City of Albuquerque Stormwater Construction Site Inspection Report

Project Name:	The Goat Brewery				
Location:	3421 Coors Blvd NW				
Site Contact Name & Agency	Sujay Thukar - Global Storage	ESC File No.	G11E071		
	sujay.thakur@gmail.com	NPDES Id. No.	NMR10020K		
Inspection Date:	10/24/19	Start/End Time:	0930/0945		
CoA Stormwater Inspector:	Timothy E. Sims				
Construction Phase:	earthwork				
Type of Inspection:	<input checked="" type="checkbox"/> Regular	<input type="checkbox"/> Storm Event	<input type="checkbox"/> Post Storm Event >0.25"	<input type="checkbox"/> 311/Complaint	<input type="checkbox"/> Follow Up

TEMPORARY EROSION AND SEDIMENT CONTROL PLAN

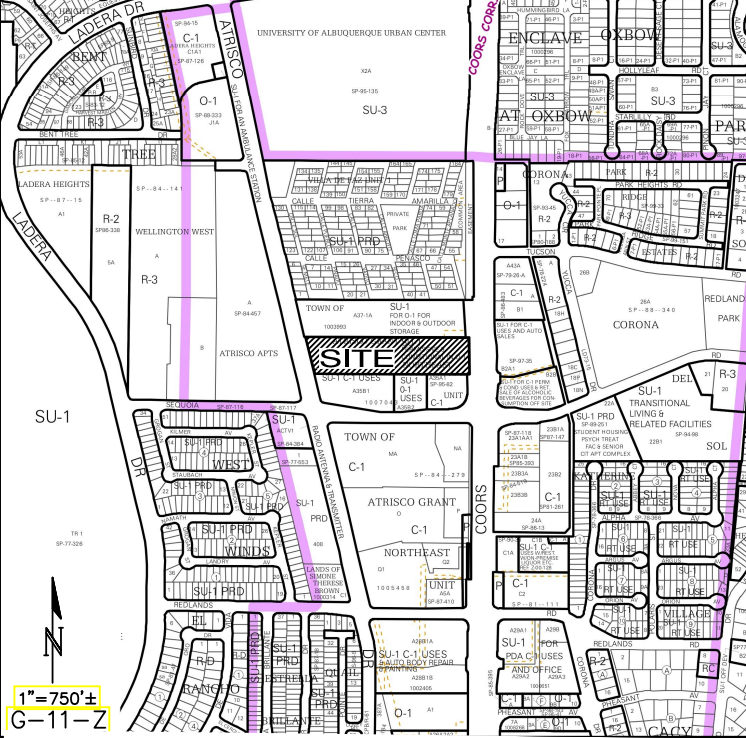
Item Number	Deficiency/ Corrective Action		
1	Track out onto Atrisco requires mitigation.		
2	Implement and install all designed BMP's for this site.		
3	Install and post NPDES posting visible to public right-of-way.		
2.1	Discharge off site? (Y/N)	No	
4	Self Inspection Reports	requested	Latest report Date: none on file
